Project Name: * Widening of I-440 from Wade Avenue to Walnut Street

April 23, 2021

Subject: **Request for Modification to the Regional General Permit Number 198200031, Section 401 Water Quality Certification, and Neuse Buffer Authorization for U-2719 – Improve Existing I-440 Beltline, from south of SR 1313 (Walnut Street) to north of SR 1728 (Wade Avenue). Debit WBS 35869.1.2**

PROJECT REFERENCE NO. U-2719	SHEET NO. 29A
RW SHEET NO.	
ROADWAY DESIGN ENGINEER	HYDRAULICS ENGINEER

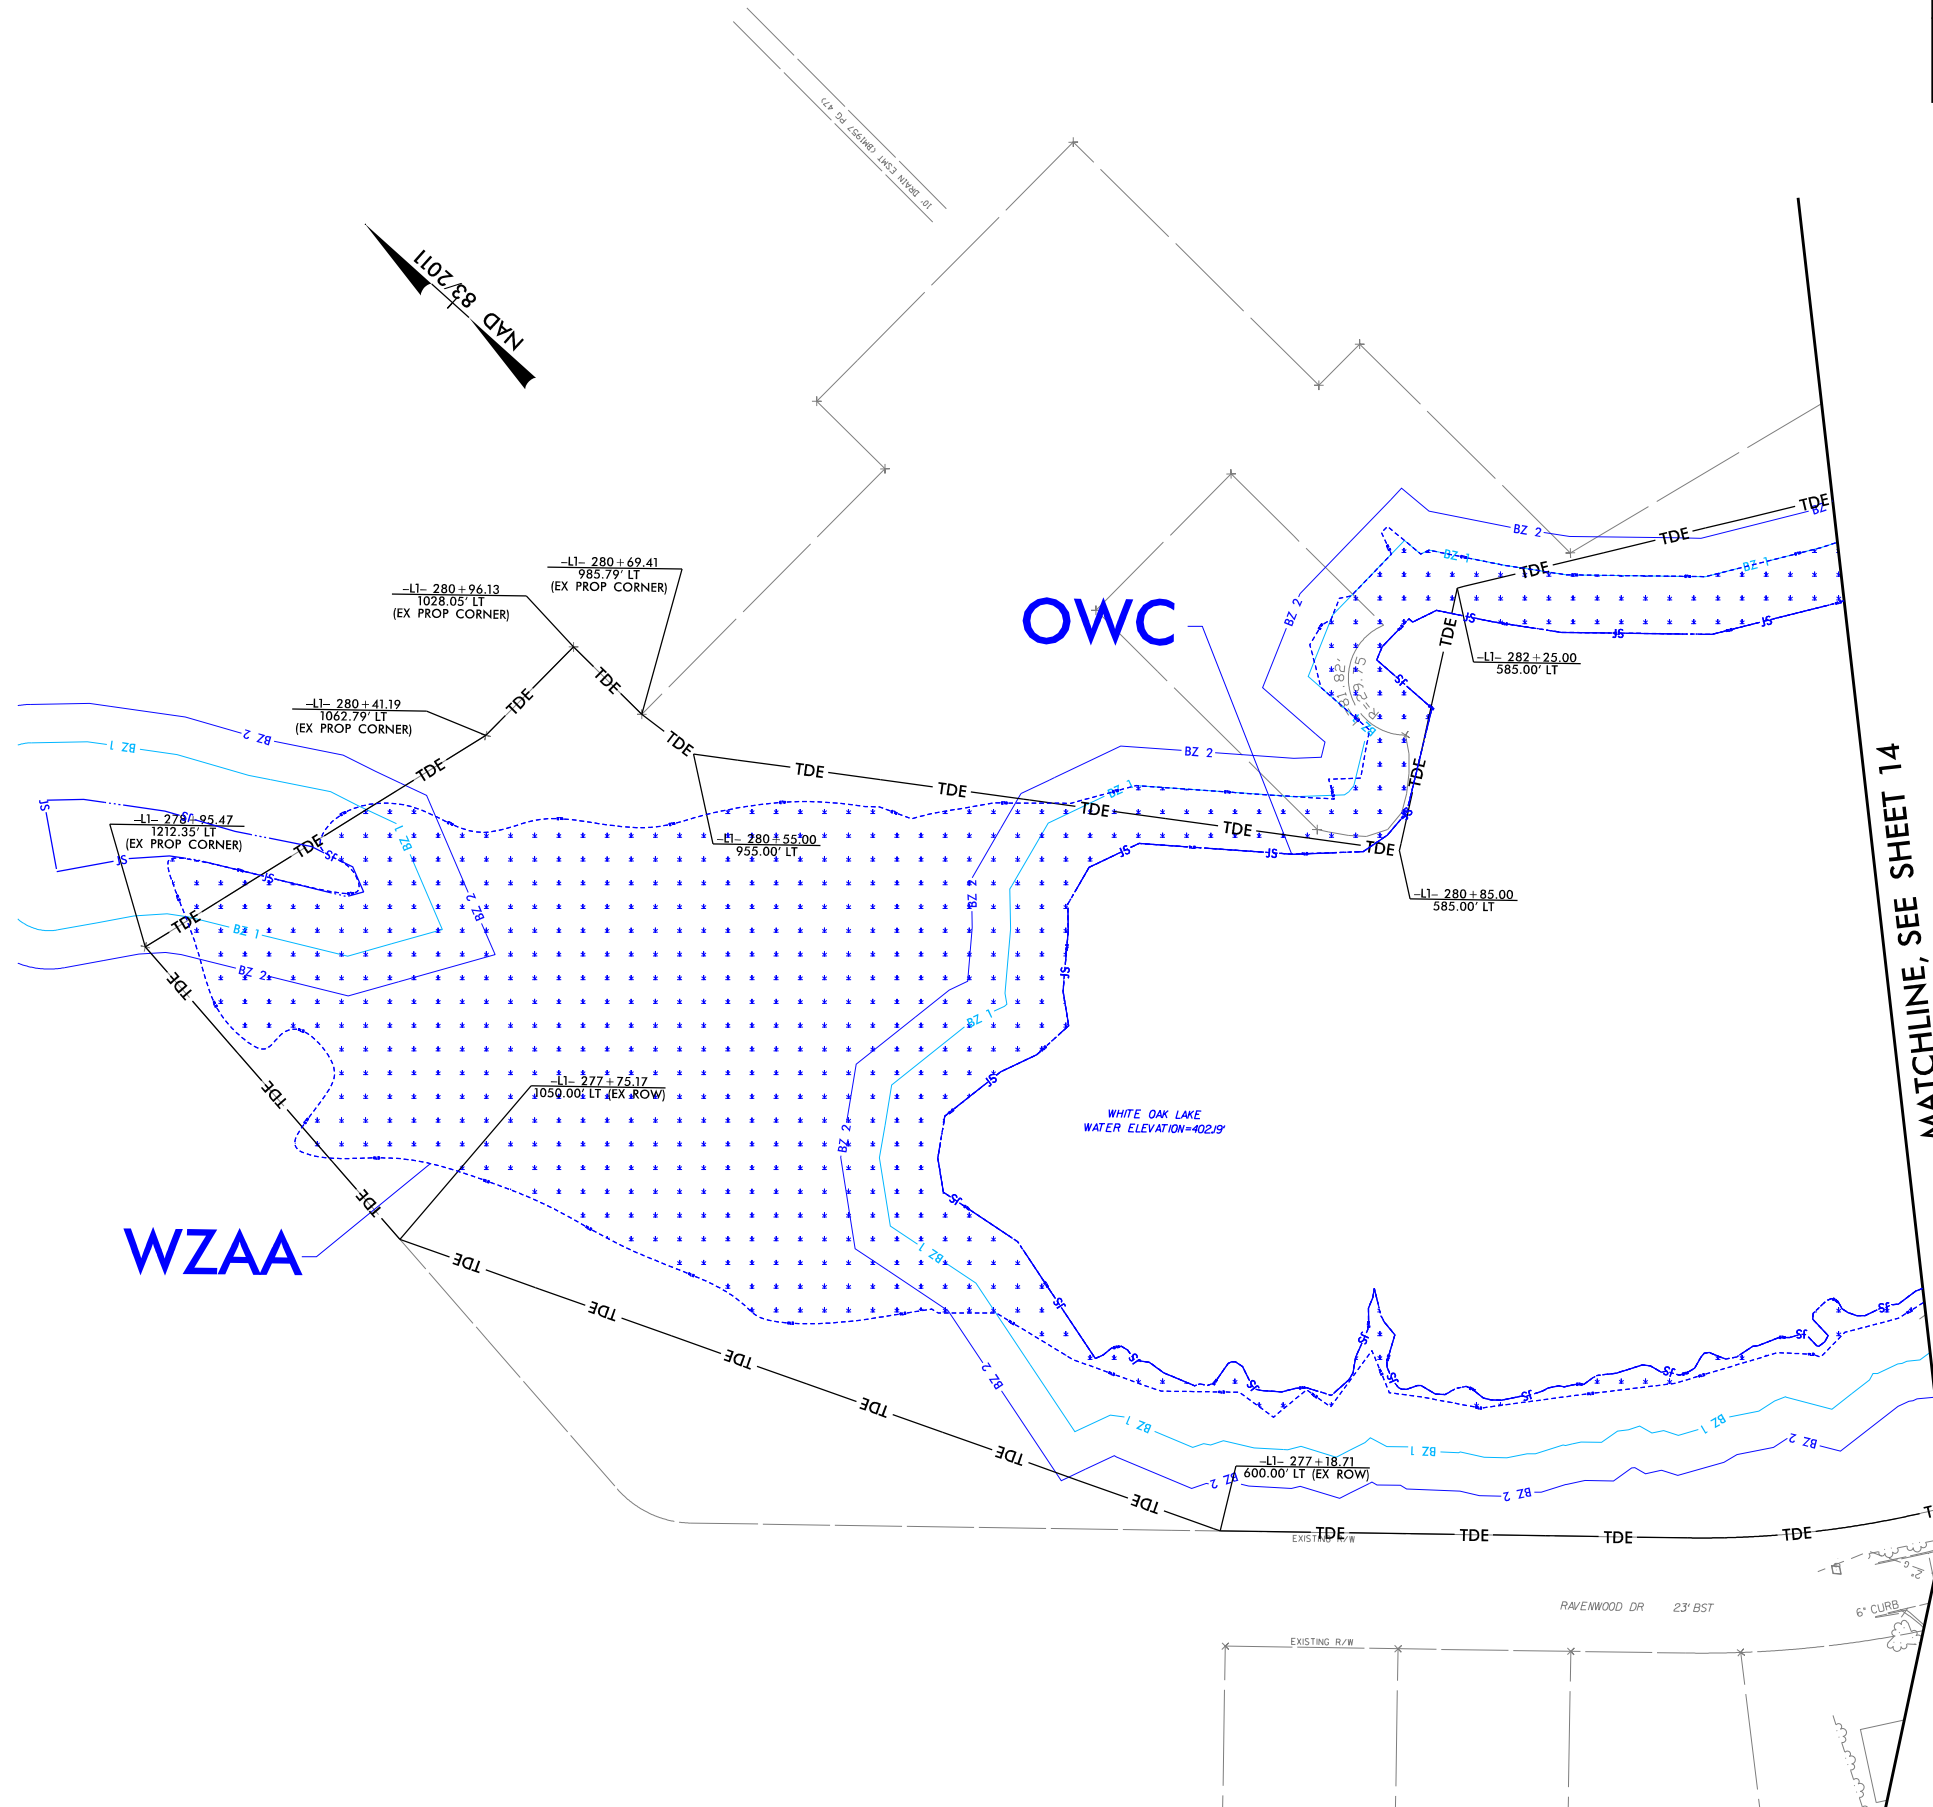
Site 22 (Sheet 14/14A/29A) – Site 22 was added to illustrate the open water impacts associated with breaching the dam of White Oak Lake. The open water impact associated with the breach is 5.10 ac. This site also includes impacts to the fringe wetlands around the lake due to the drawdown of the lake. This area has been hatched on the attached plan sheets and the 2.65 ac of wetland fringe has been noted at the bottom of the summary impact table since it does not match any of the wetland impact types illustrated on the summary table.
